To: Lisa Gish
Engineering I
El Paso County

From: Eric Gunderson, P.E.,
Kimley-Horn and Associates, Inc.

Date: April 6, 2023

Subject: Widefield Parks and Recreation – Recreation Center – Pond Outlet Structure

C7.5

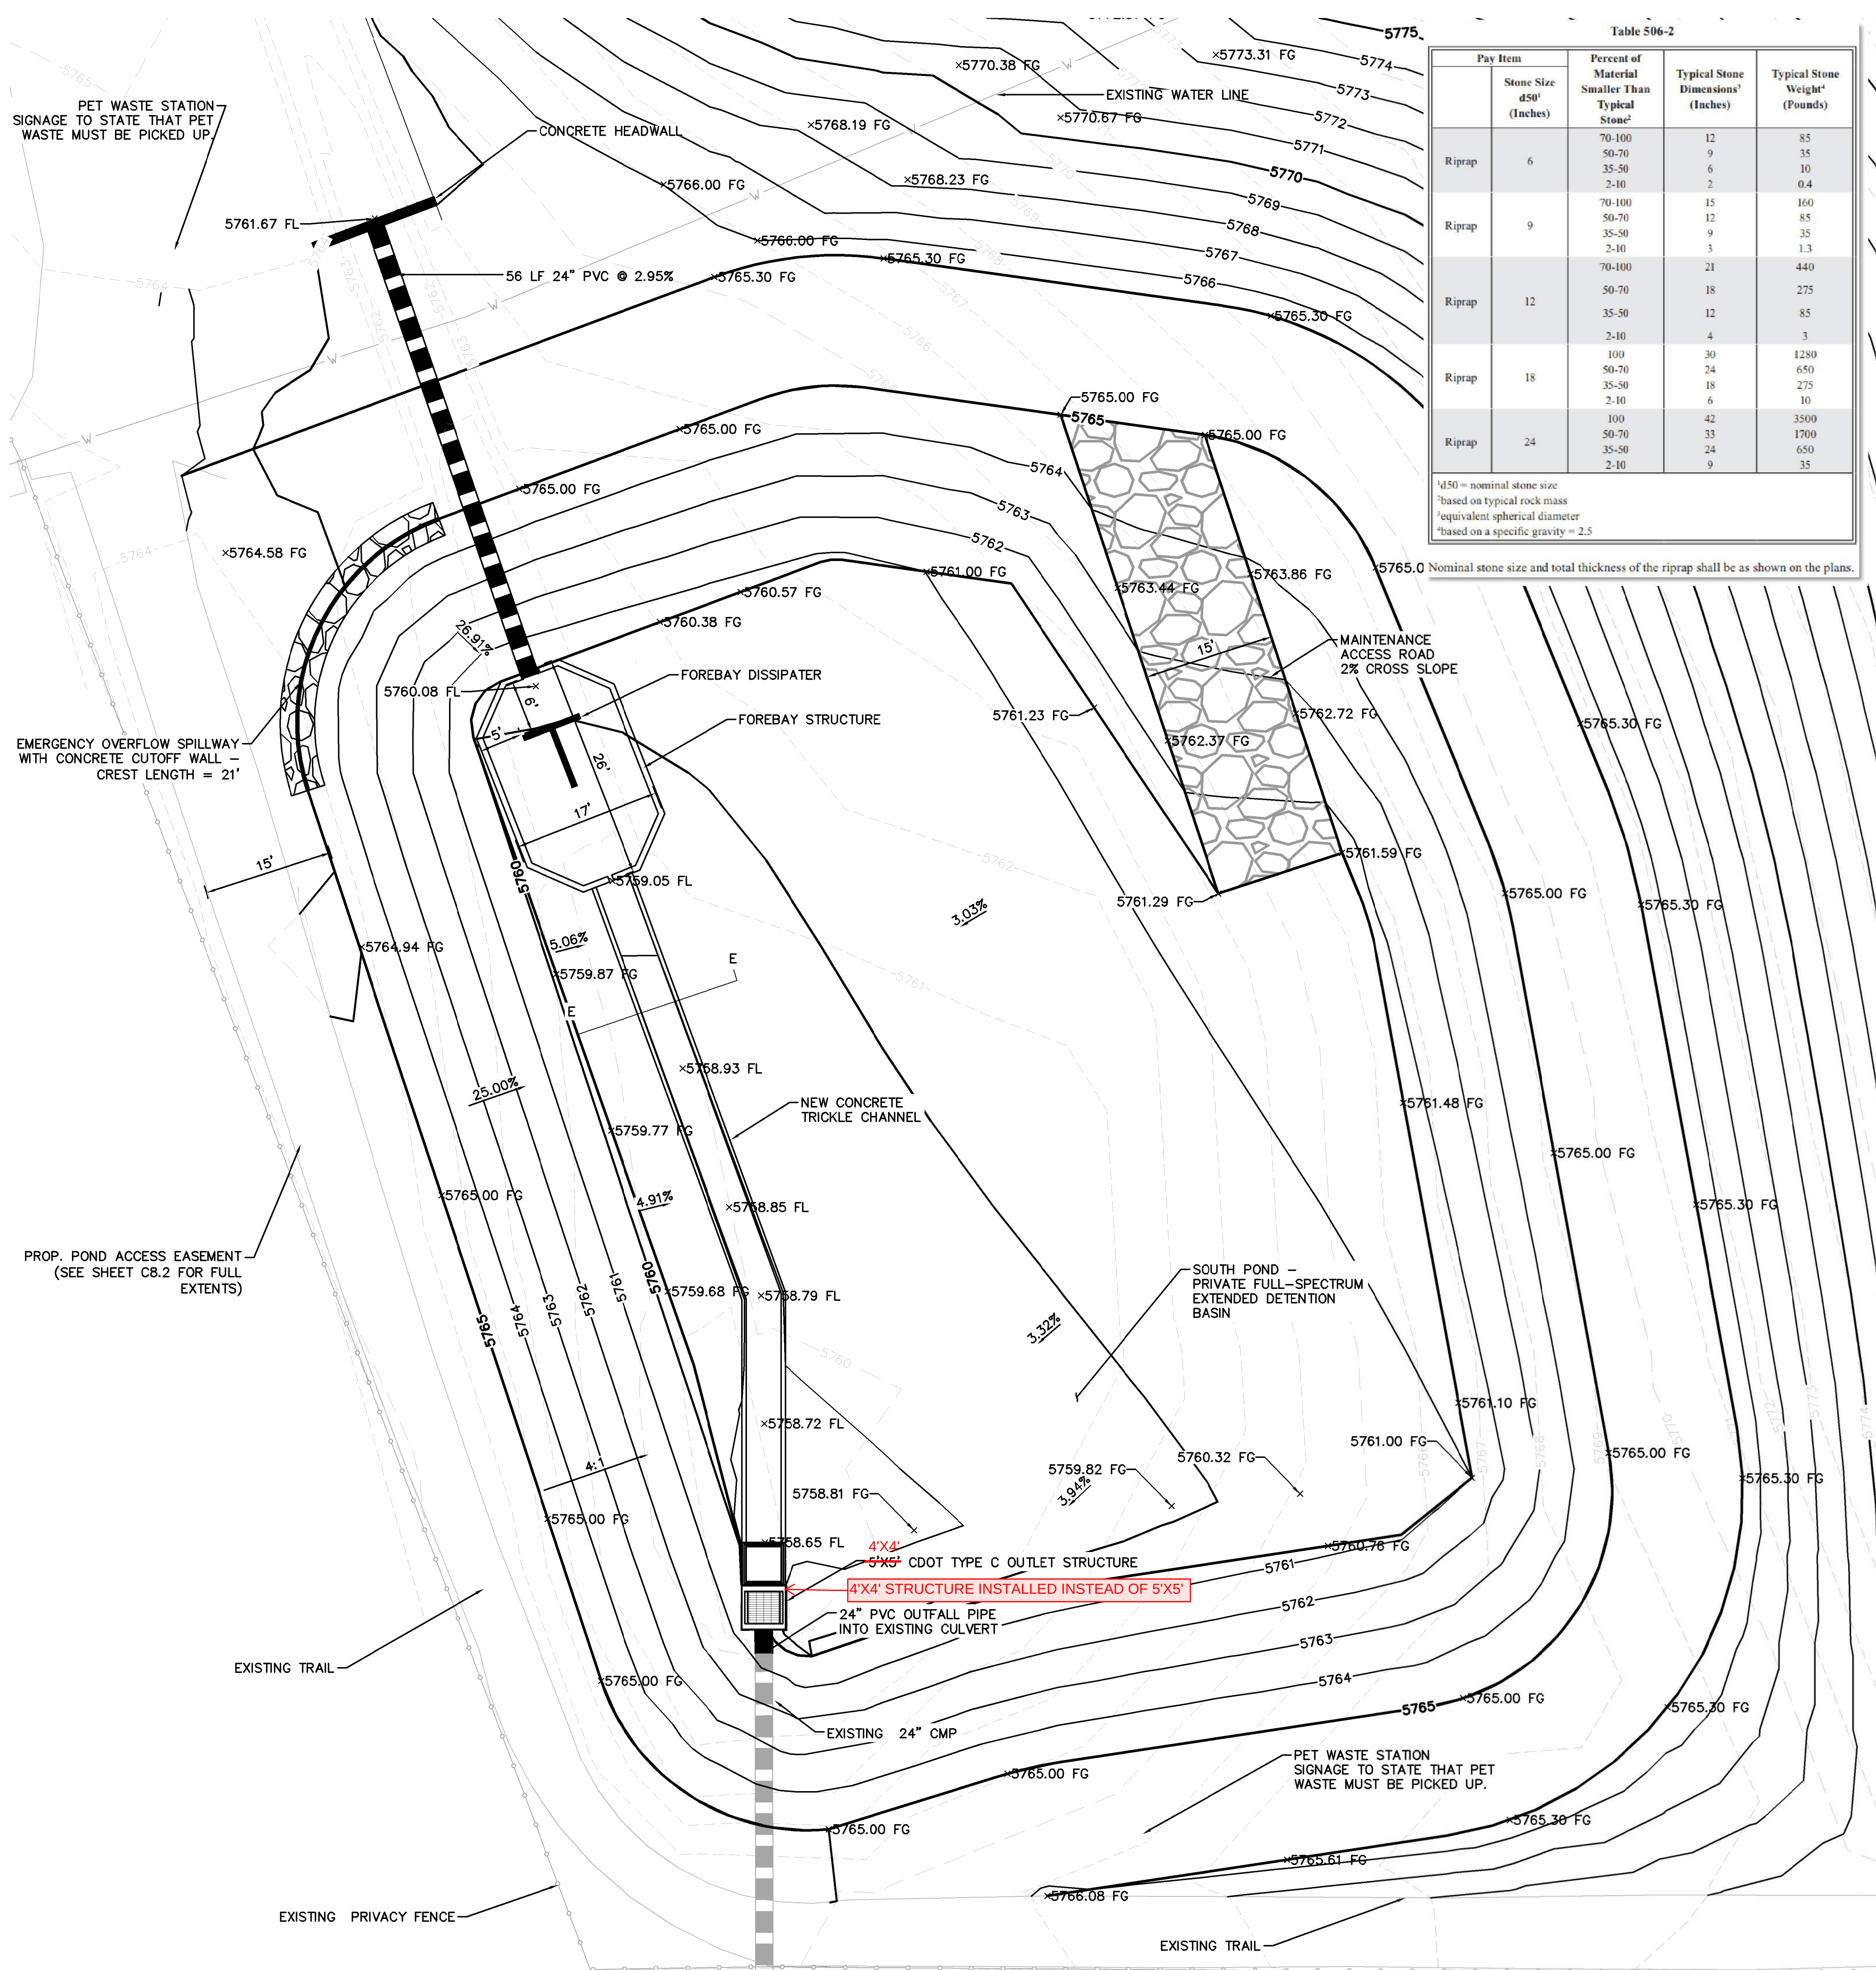
Based upon an email received by Kimley-Horn from Lisa Gish dated April 4, 2023 4:09PM, it is understood the proposed outlet structure in the extended detention basin at the subject site has been constructed differently than the approved plans dated 2/28/23. The approved plans call for a 5'x5' Type C CDOT structure with 4:1 sideslope/grate. Based upon the referenced email from the County, it is understood the structure was installed at 4'x4' and was installed with a flat top instead of the 4:1 sloping grate.

Again, this is what I am asking for. You even acknowledged yourself that one is necessary.

Kimley-Horn proposes lowering the restrictor plate on the outlet pipe 6" for a total of 12" of clearance as noted. This will maintain the appropriate pre-development vs. post development flow ratios and drain times to be in compliance with the approved final drainage report for the project.

Based upon the information above and analysis performed herein and the adjustment to the restrictor plate, the change in size and slope of the outlet structure is acceptable to the engineer of record.
